Attachment A – Hawkesbury Centre of Excellence Response to Request for Further Information

Figure 3. The components of the Subject Land.

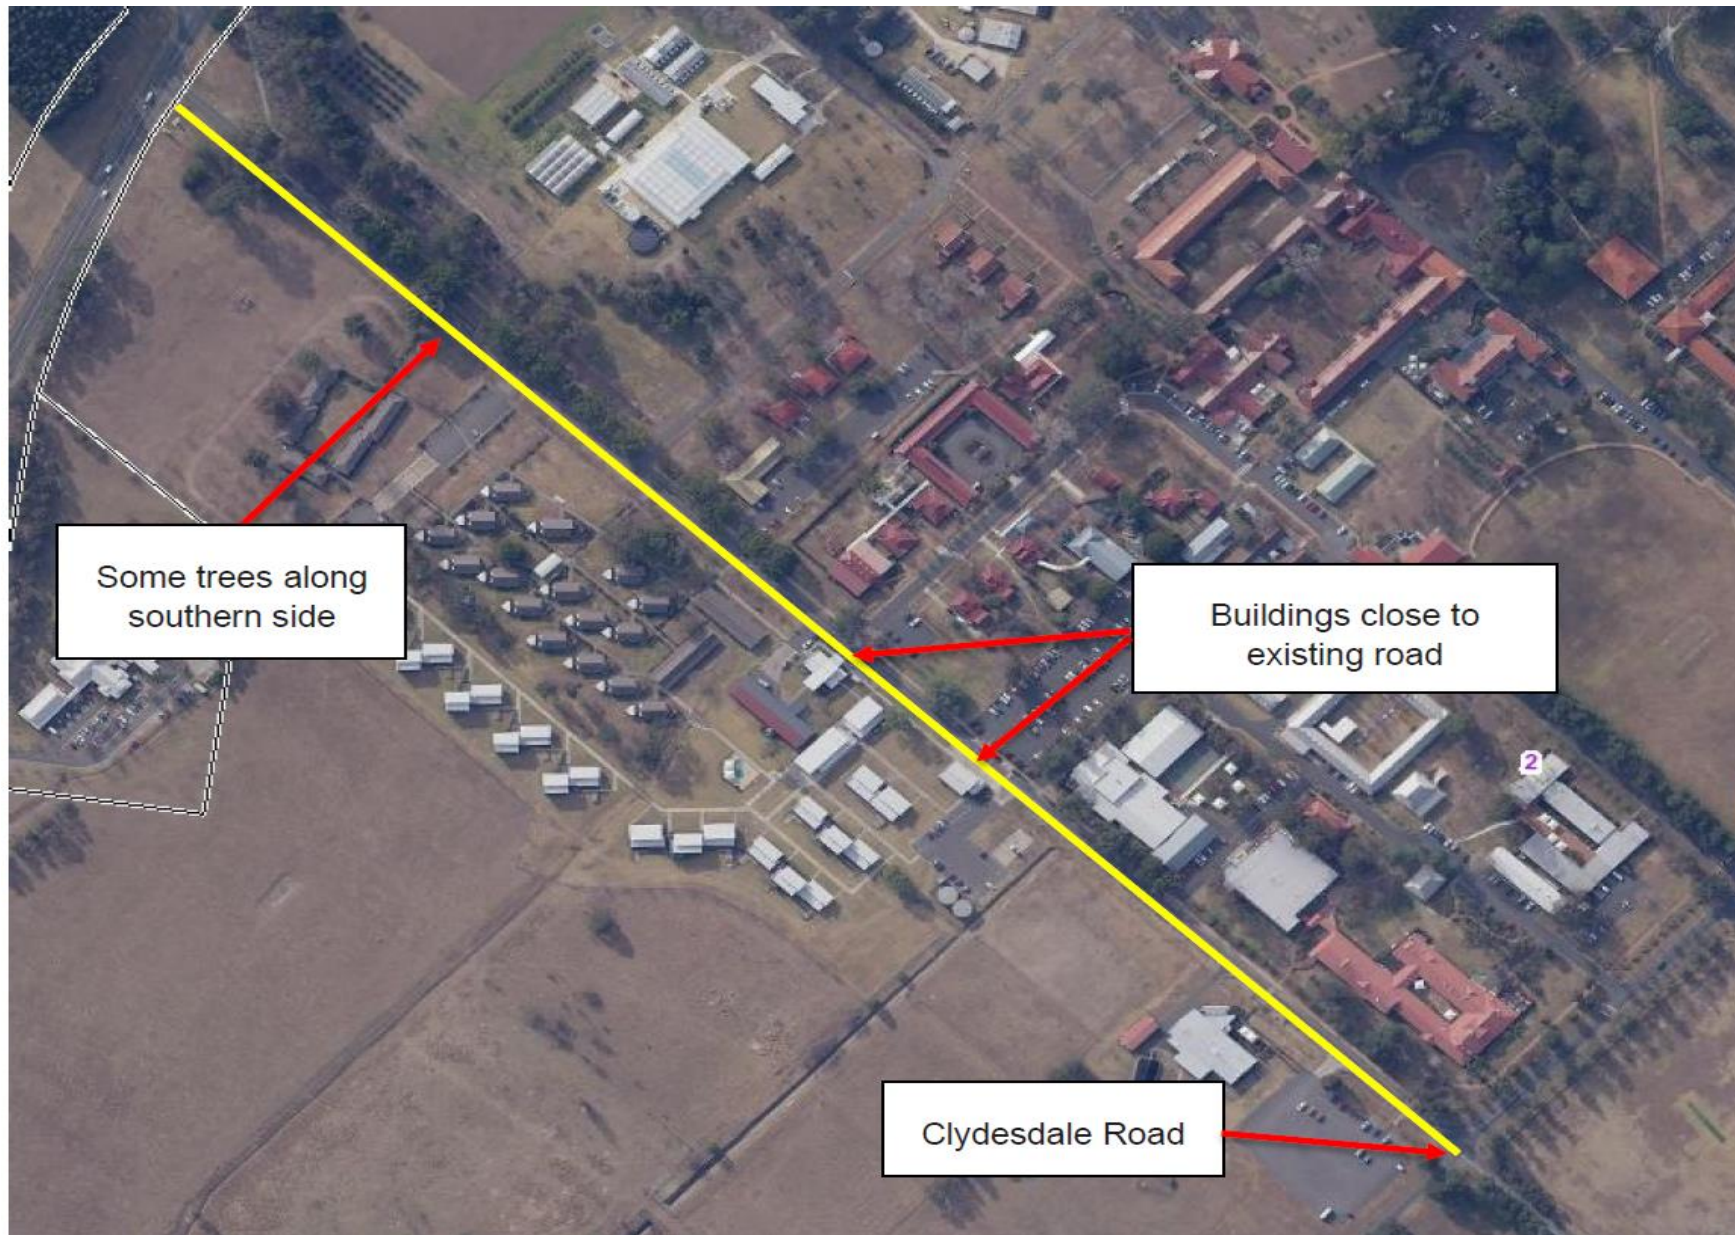
In response the RtS notes the proposed dam/OSD will remain in the proposed location but the northern-most agricultural plot has been realigned in the top western corner to reduce the impact on remnant canopy and hollow bearing trees. Details are required on the location of this remnant canopy and the number of trees and species that will no longer be impacted by the realignment of the northern-most agricultural plot. Based on the updated BDAR it appears that no PCT 835 with remnant canopy is to remain on the site and that offsets are required for its removal.	Previous and updated proposed site plans reviewed and no changes to design affecting remnant canopies can be found. An updated BDAR is provided as Attachment C .
Comparing Figure 10 and the Proposed Site Plan in the updated BDAR for the RtS, it appears the proposed agricultural plots are still to be located where PCT 835 – remnant canopy and hollow bearing trees occur. The updated BDAR still includes the same Proposed Site Plan as the previous BDAR as they are both dated 24 March 2021. The Proposed Site Plan included in	Refer to Figure 3 within the updated BDAR provided as Attachment C .

Drawing Title
Overall Tender Plan

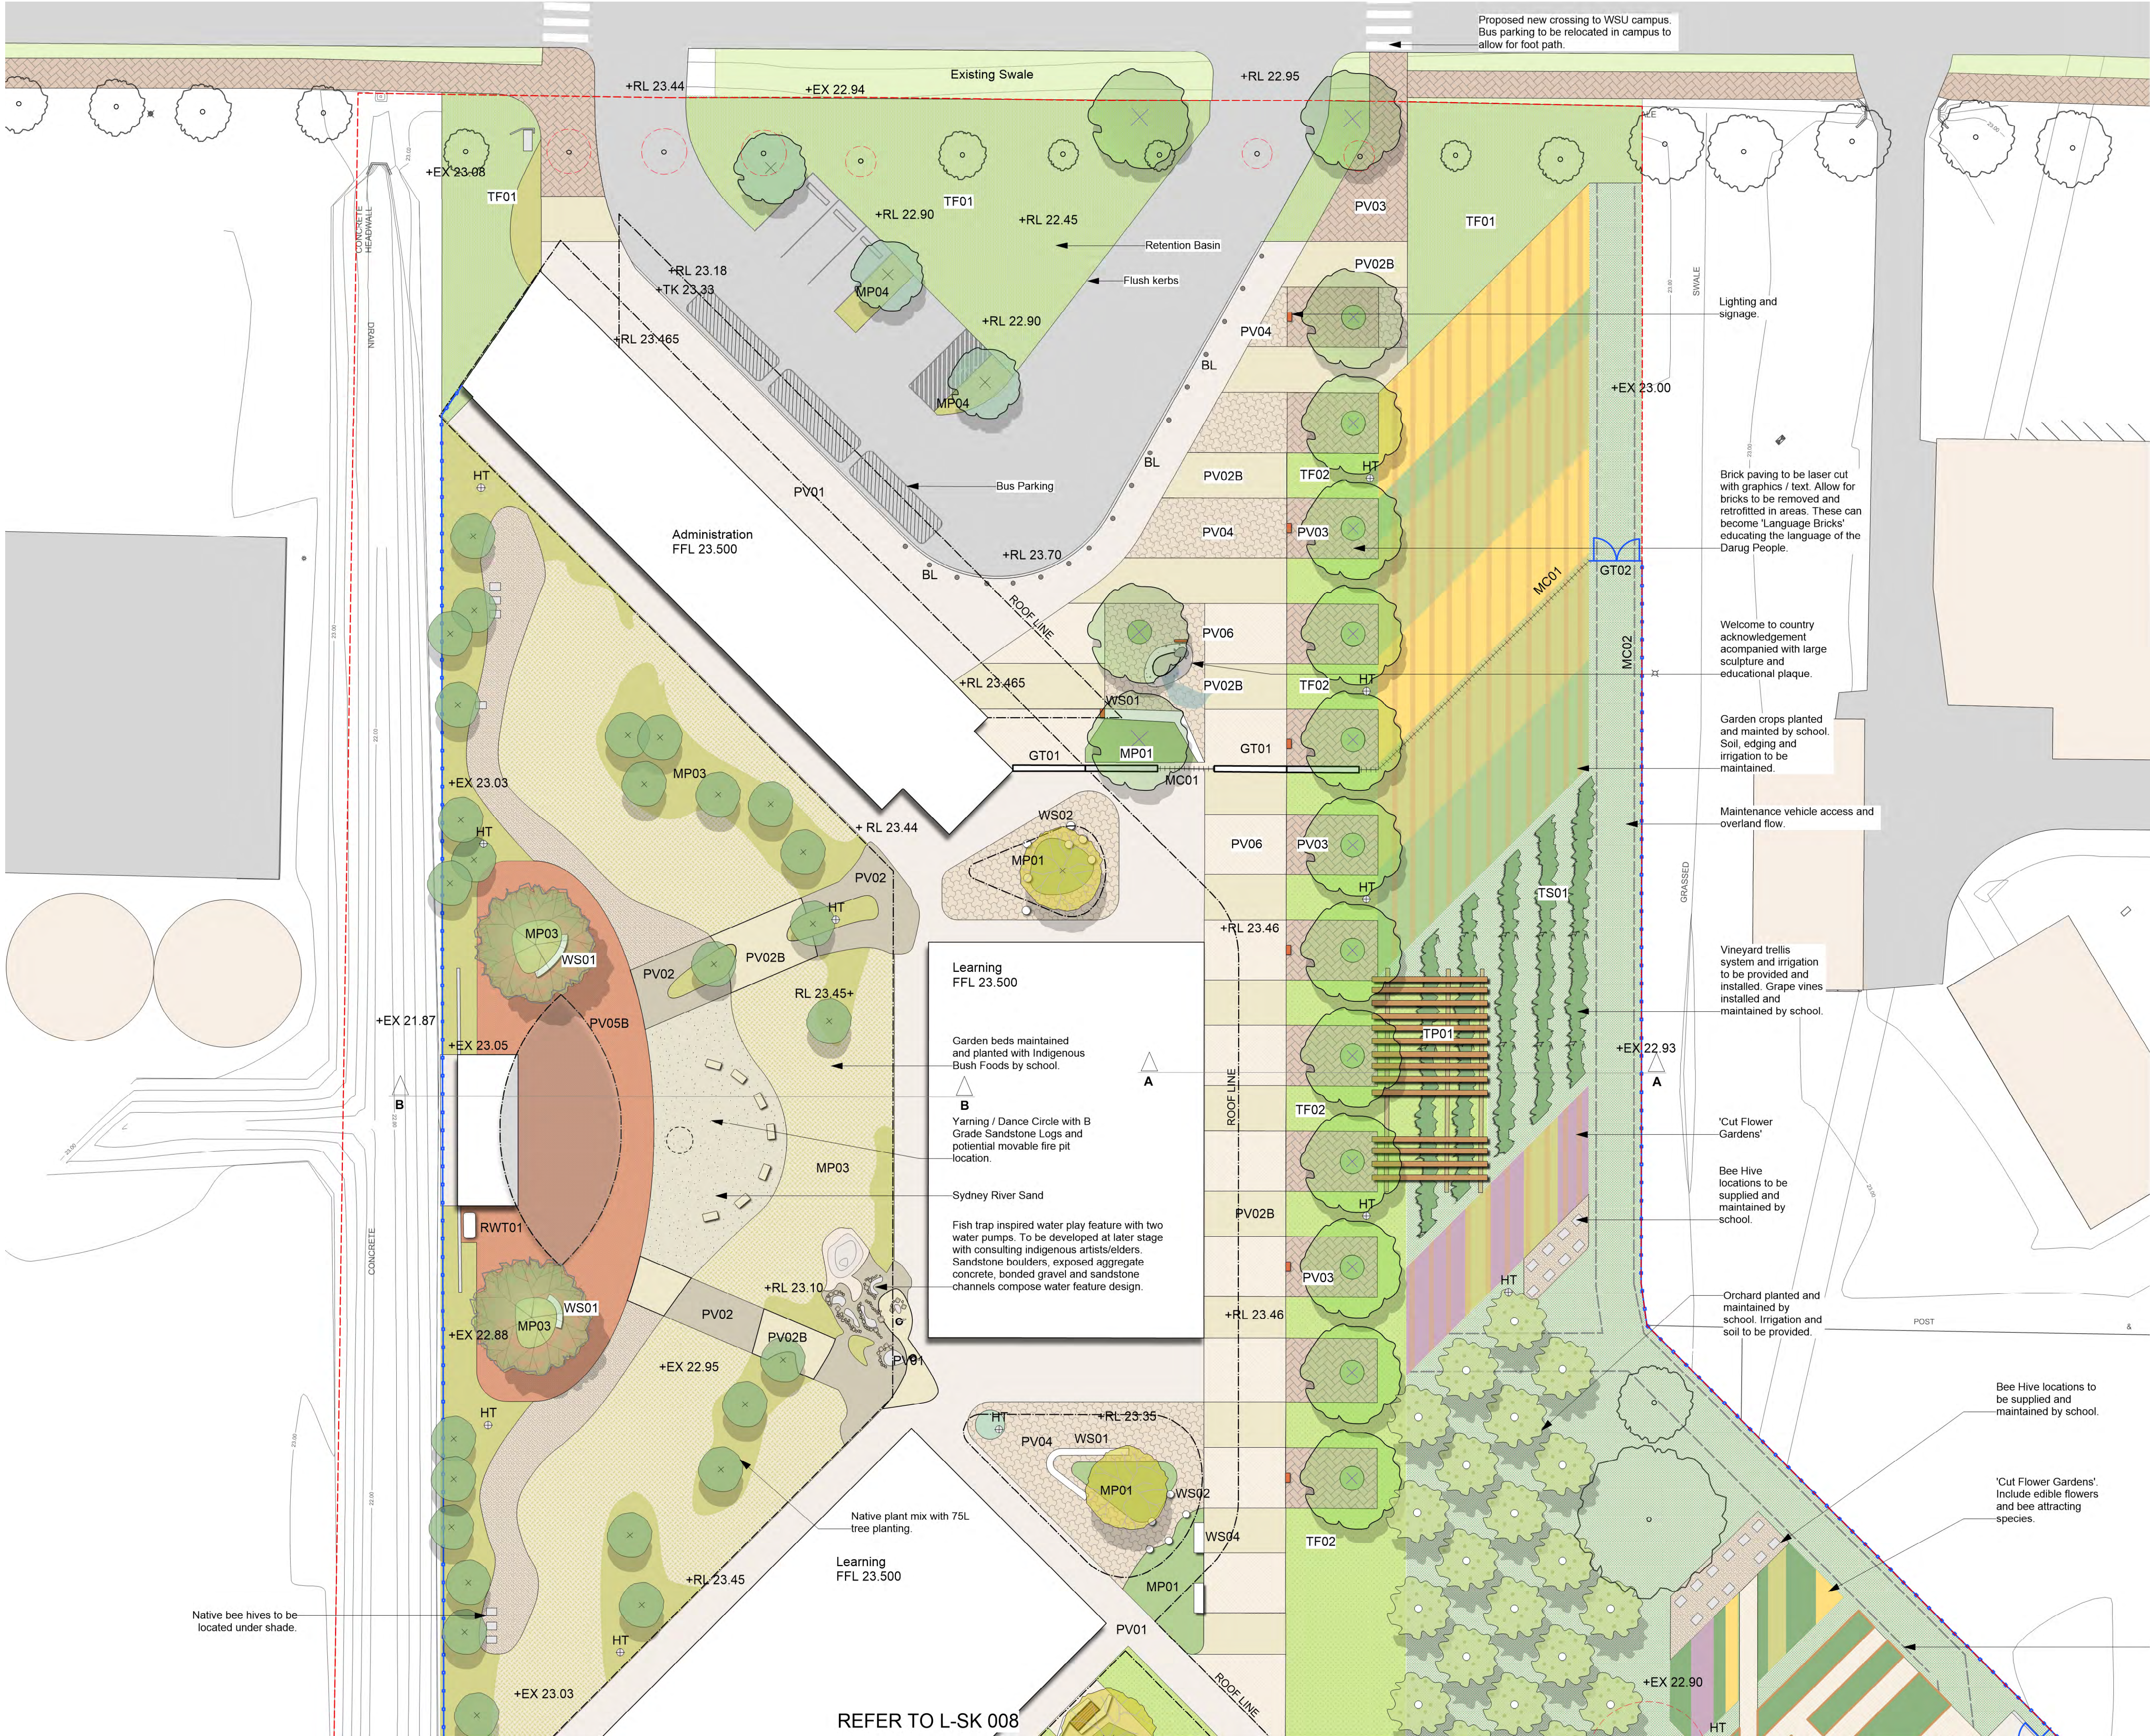
<p>EES advised the RTS should provide details on:</p> <ul style="list-style-type: none"> • the total number of trees to be removed by the project, the tree species, and whether the trees to be removed are exotic, invasive, non-local natives or local native species • the number of replacement trees, the replacement planting locations, and the replacement plant species. 	<p>Refer to Refer to Updated AIA Report contained in Attachment D and AIA Report for Vines Drive contained in Attachment E. Replacement trees are found in Landscape Plan SK012.</p> <p>No objection, subject to review of draft conditions.</p>
